Application No: FP/125/25/HH
Site Address: 14 First Avenue Felpham PO22 7LG
Description of works: Single storey rear extension. First floor side extension above existing ground floor.

Felpham Parish Council object to this application on the following grounds:

DRAWING TITLE
PROPOSED PLANS

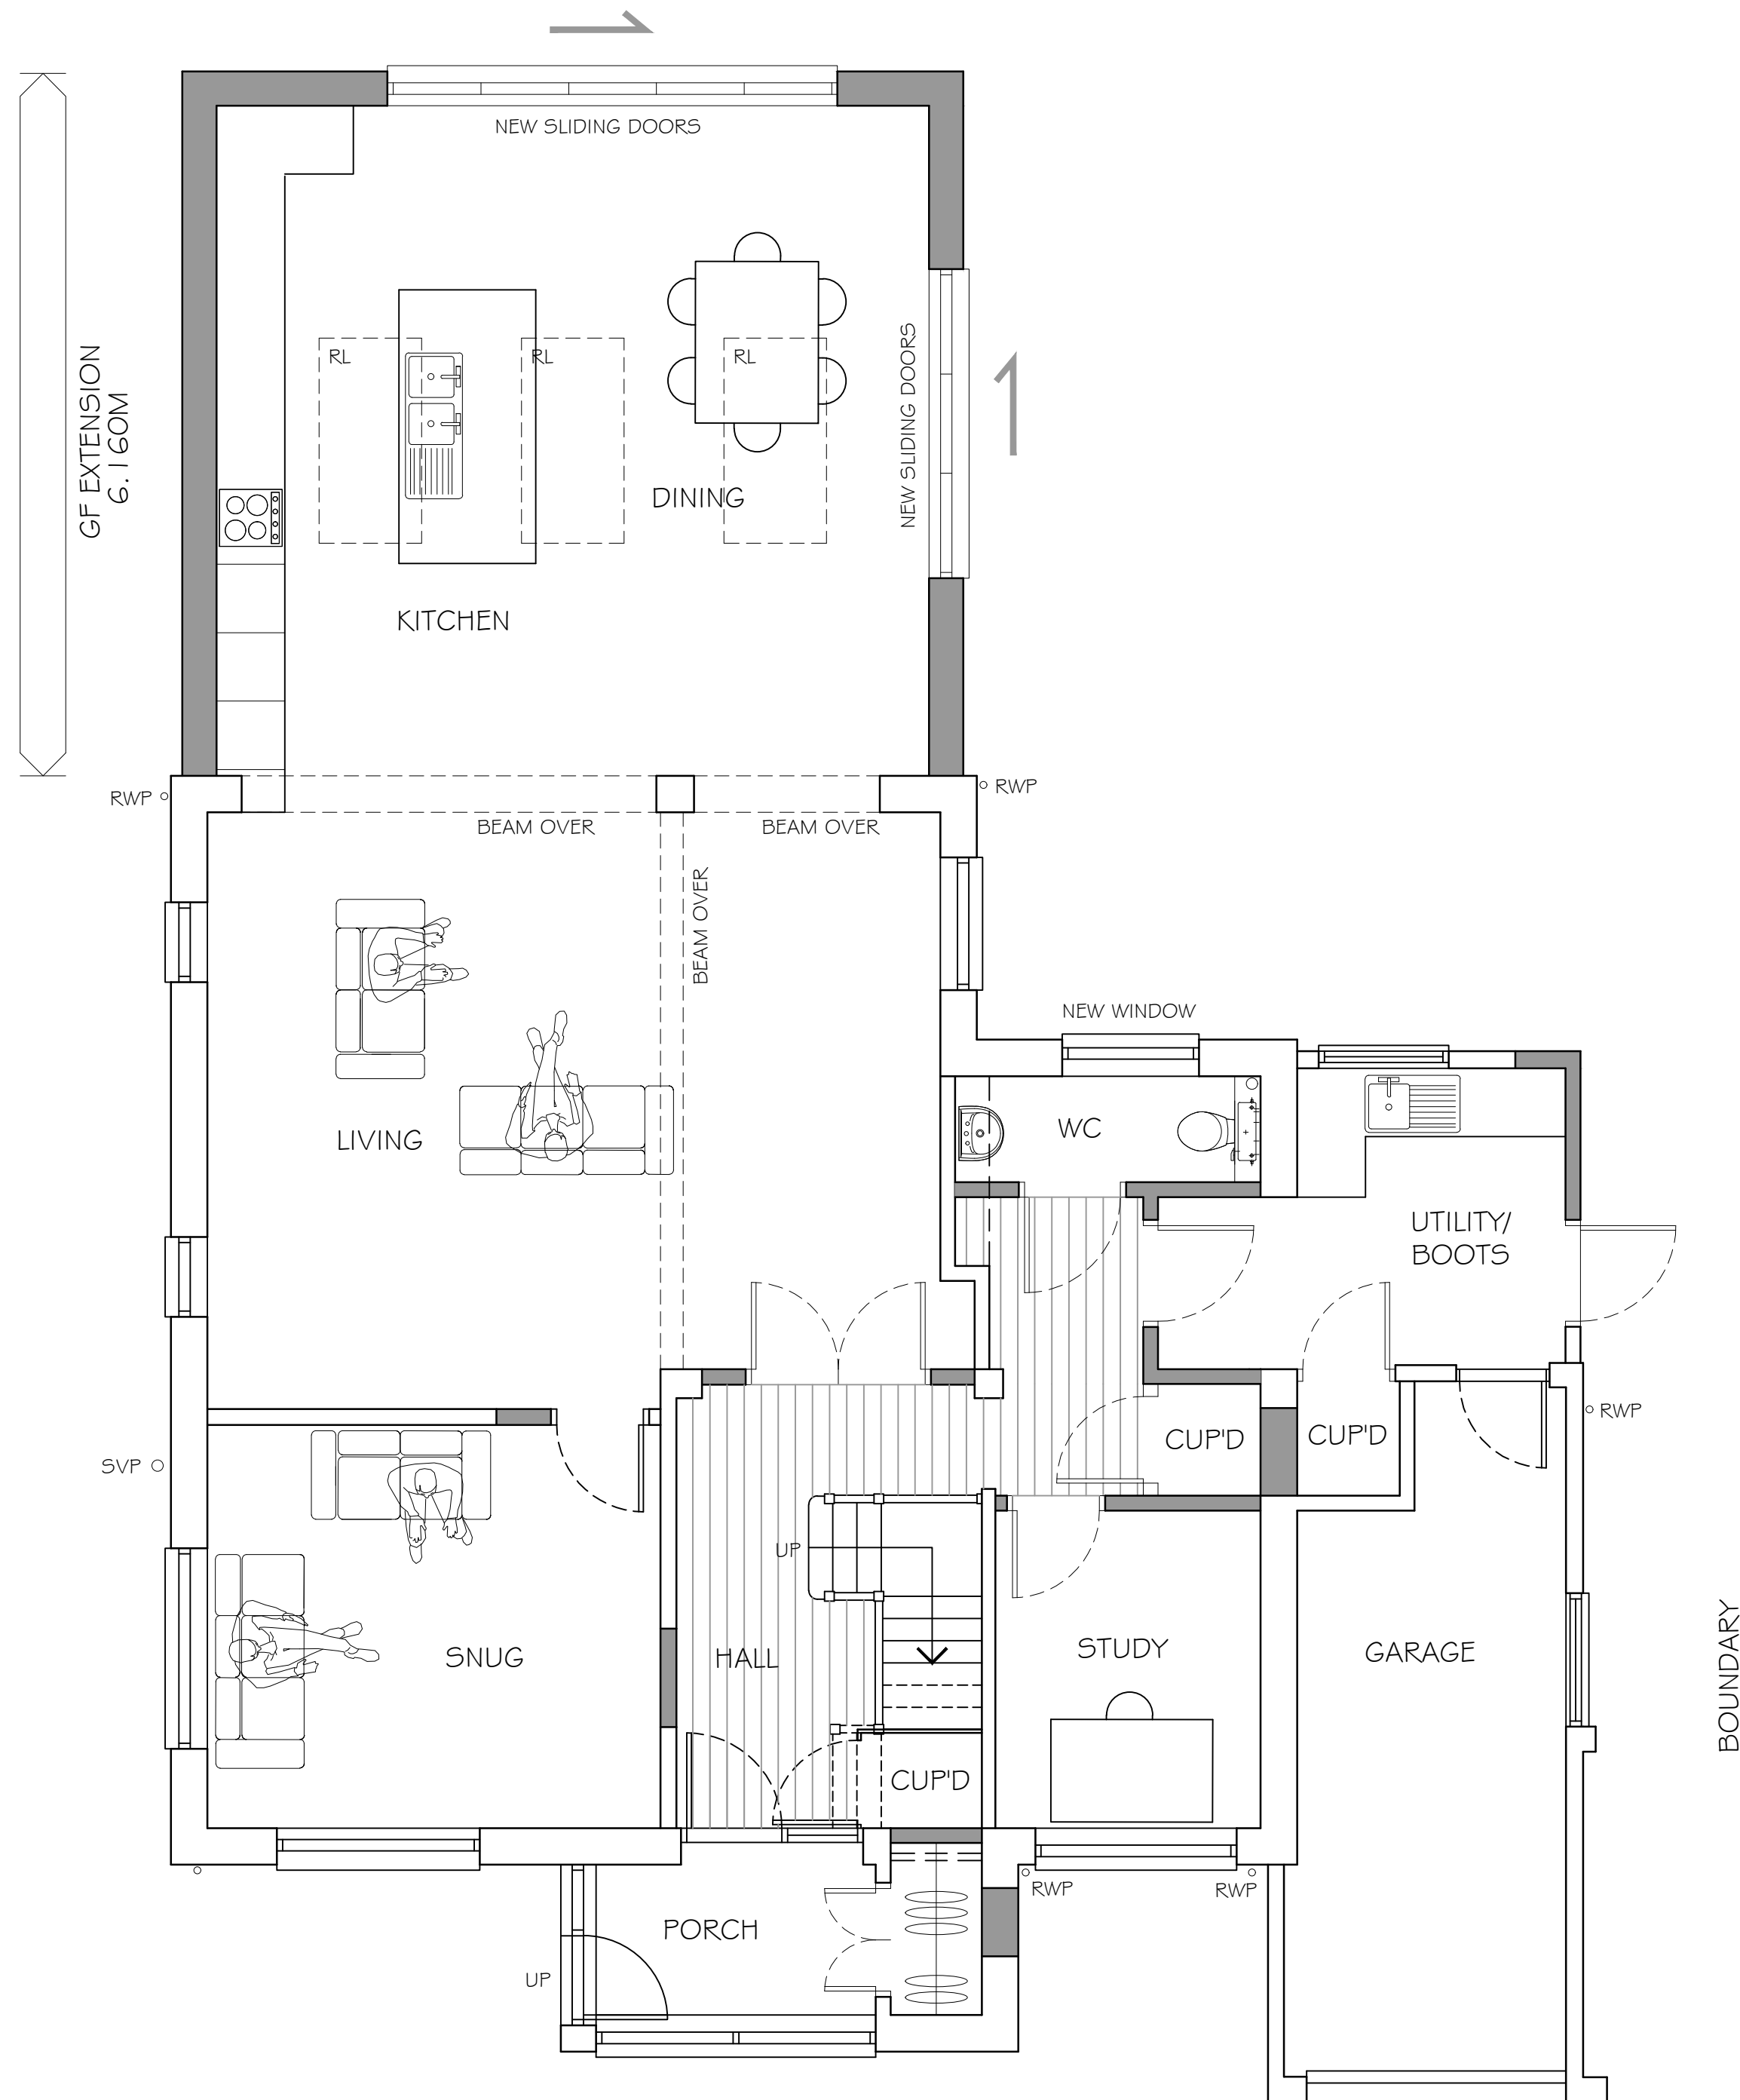
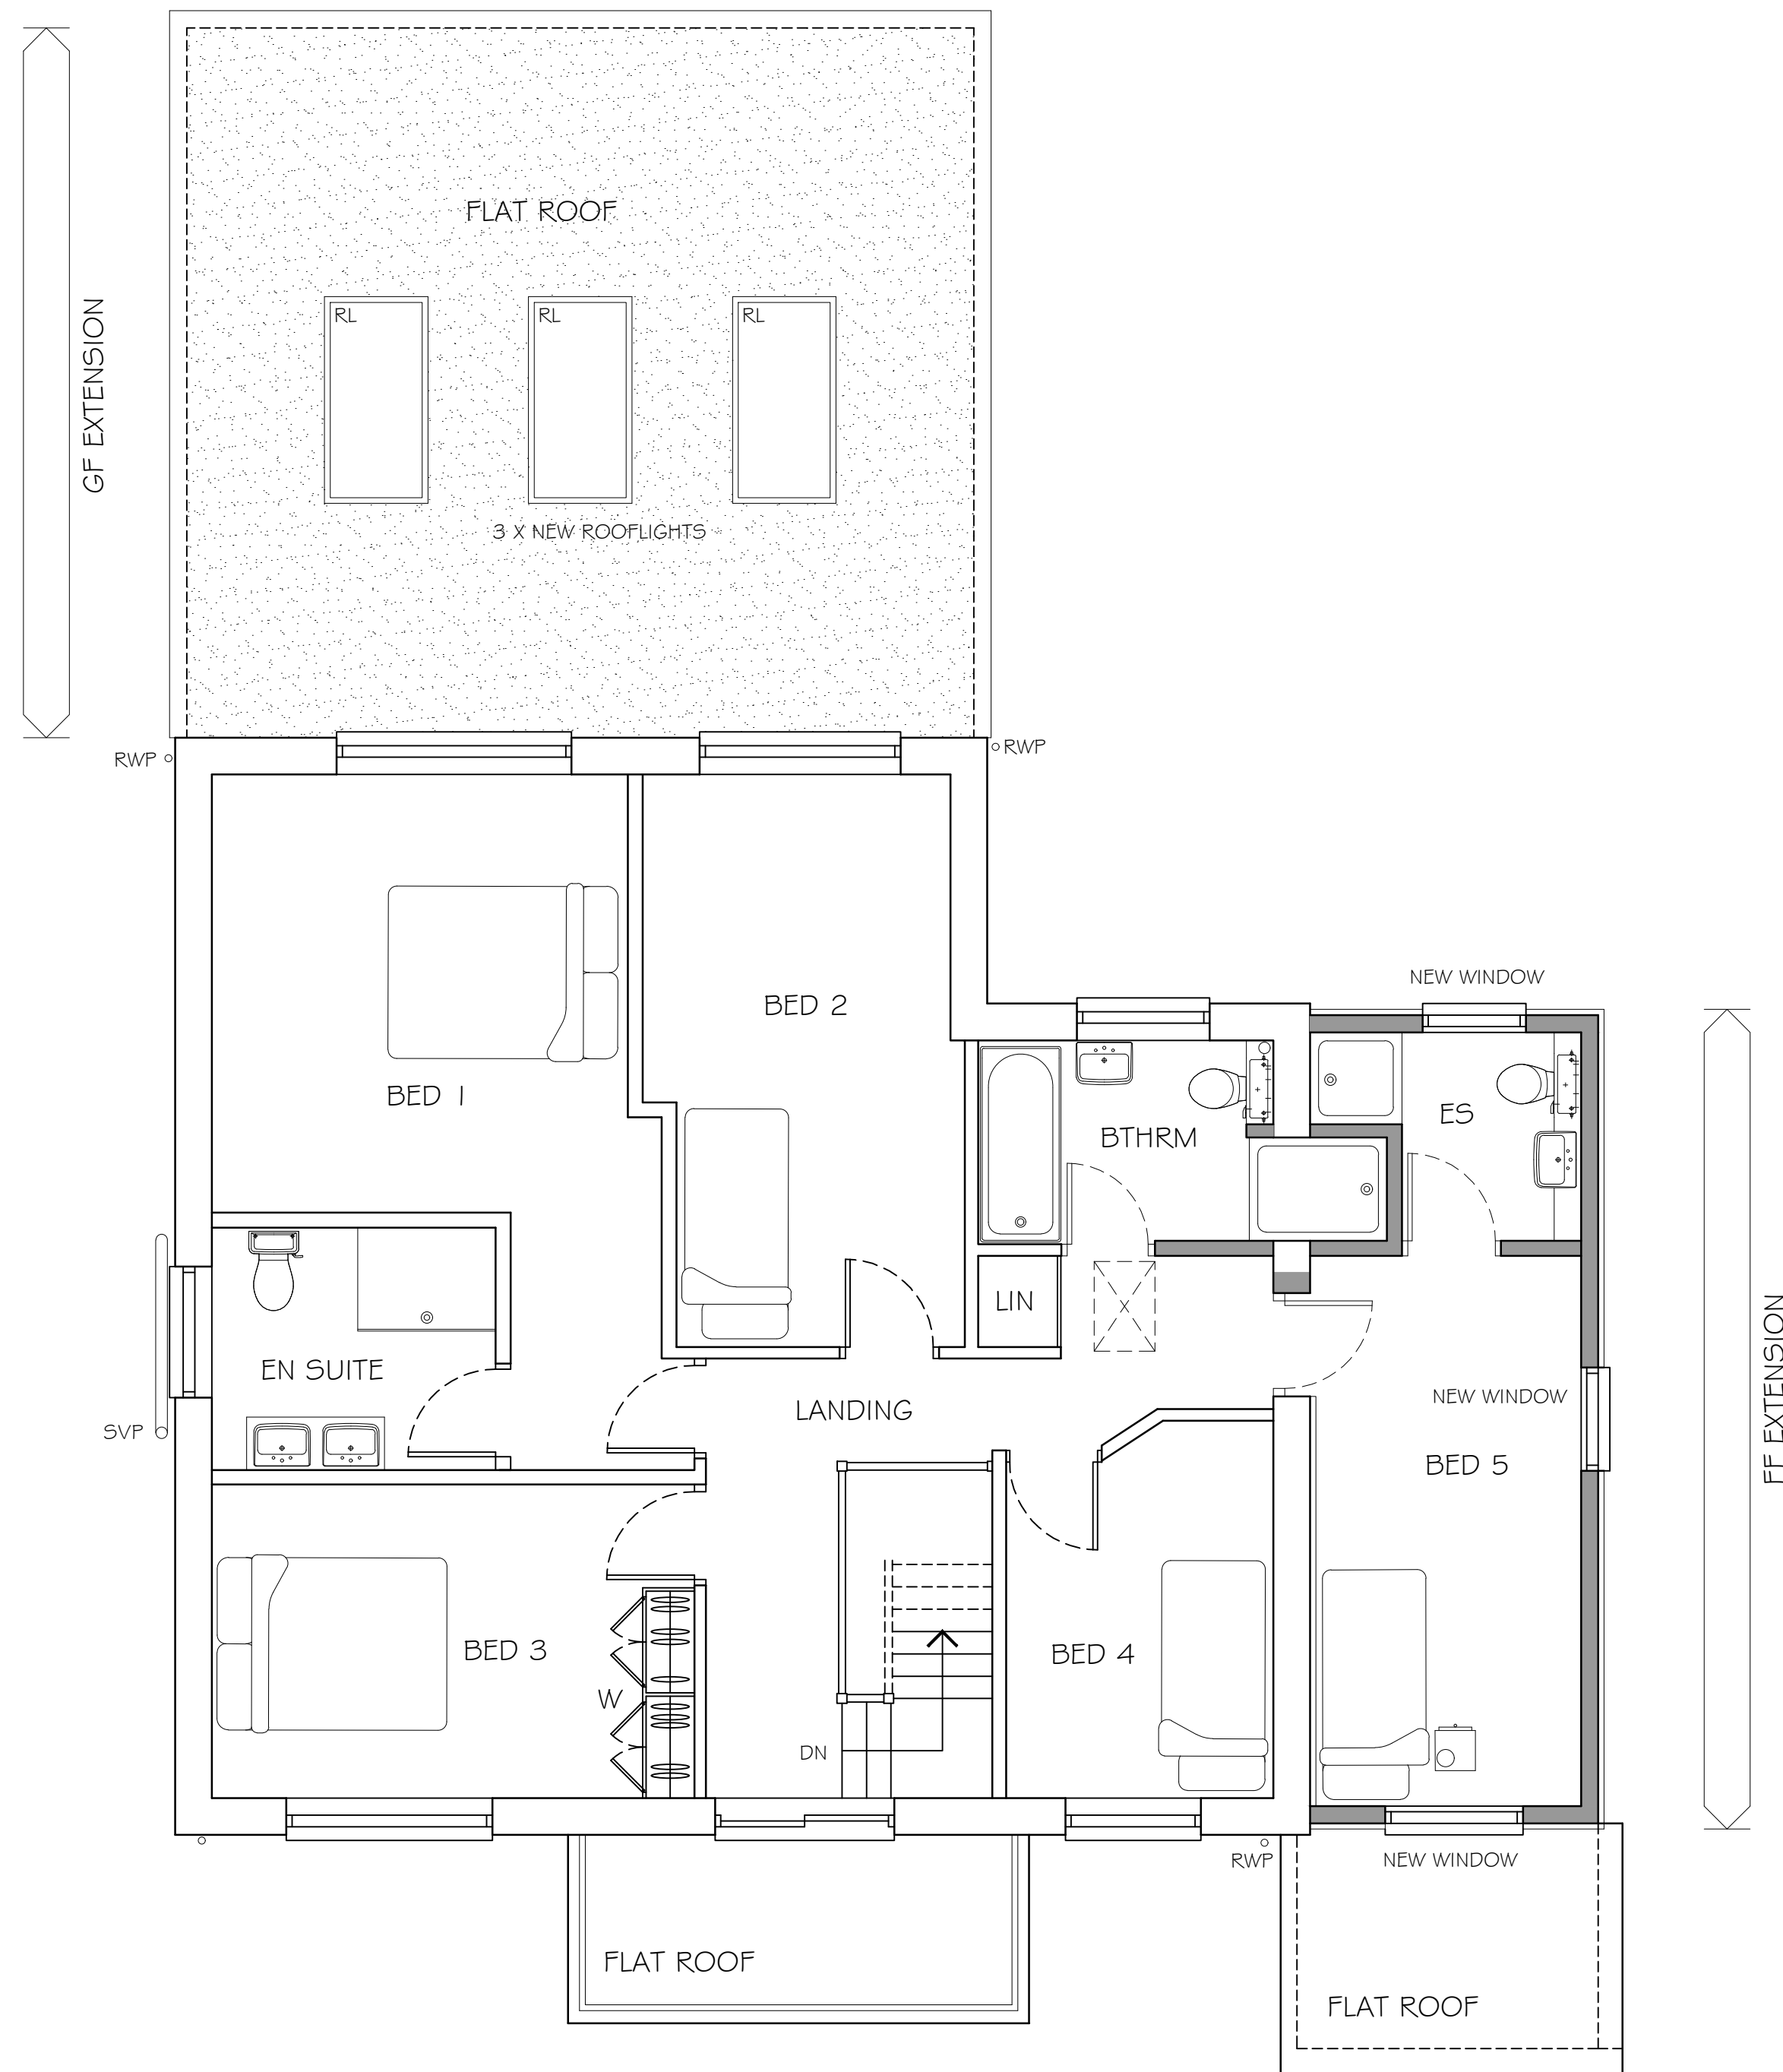
Not clear if a 1m gap from the boundary has been maintained on the first floor.

Bedroom 5 - There may be issues with overlooking and it is unclear whether this is diffused glass.

PROPOSED BLOCK PLAN
(1:500 SCALE)

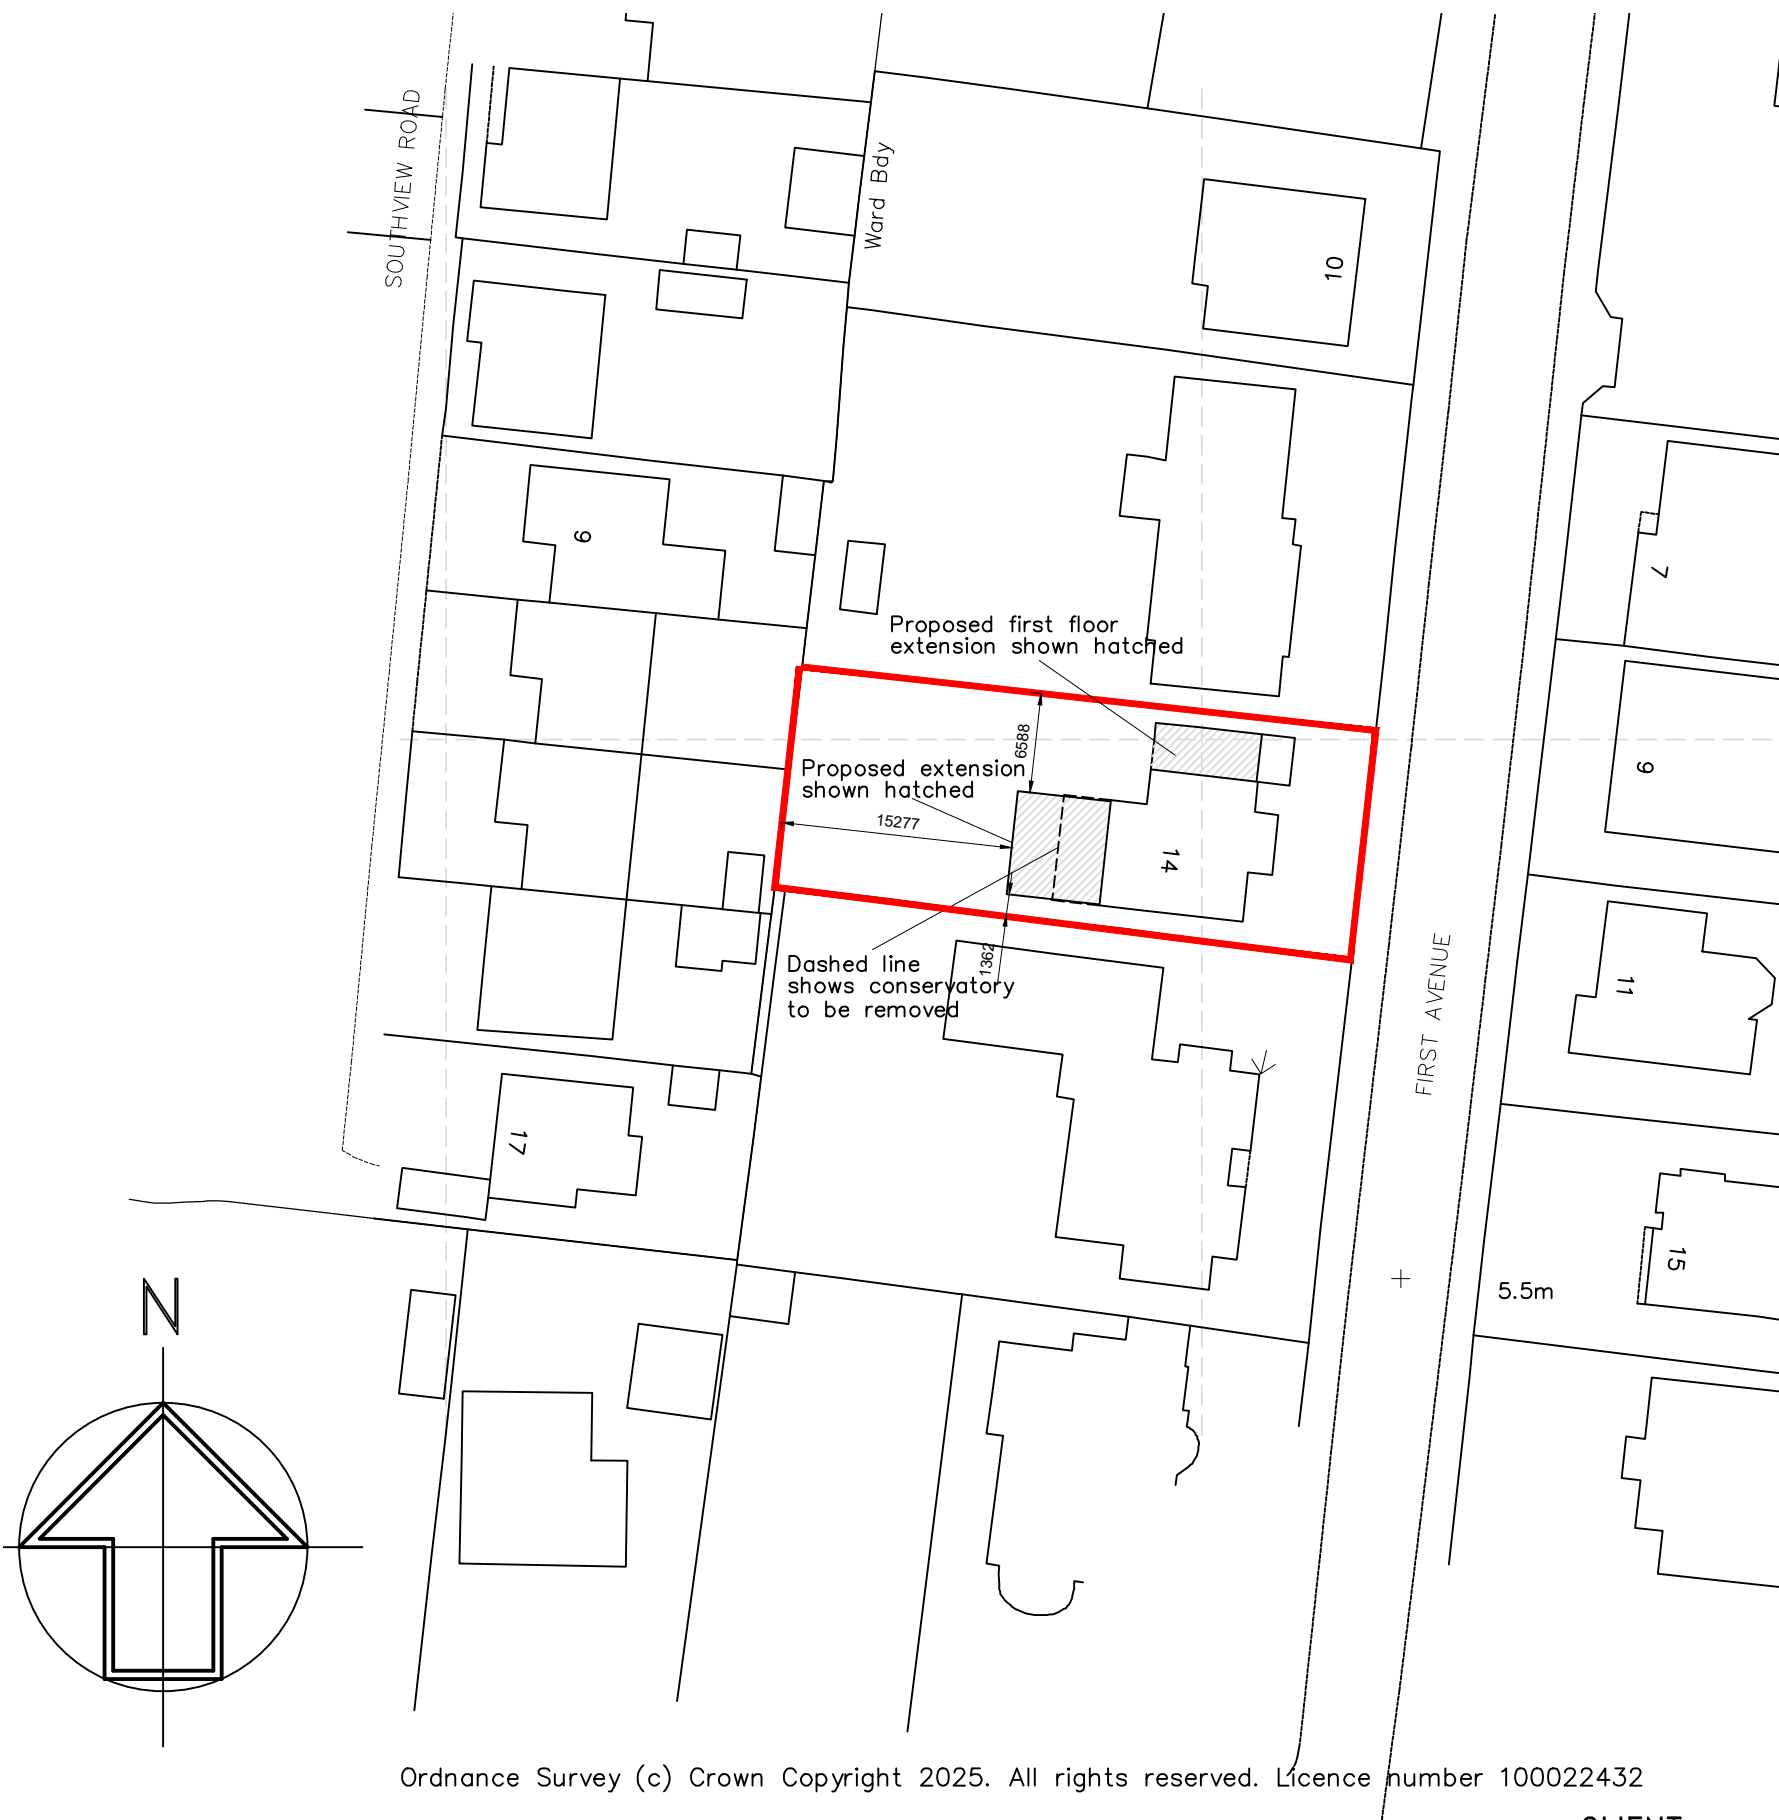
Fails to comply with Arun District Council Parking Requirements.
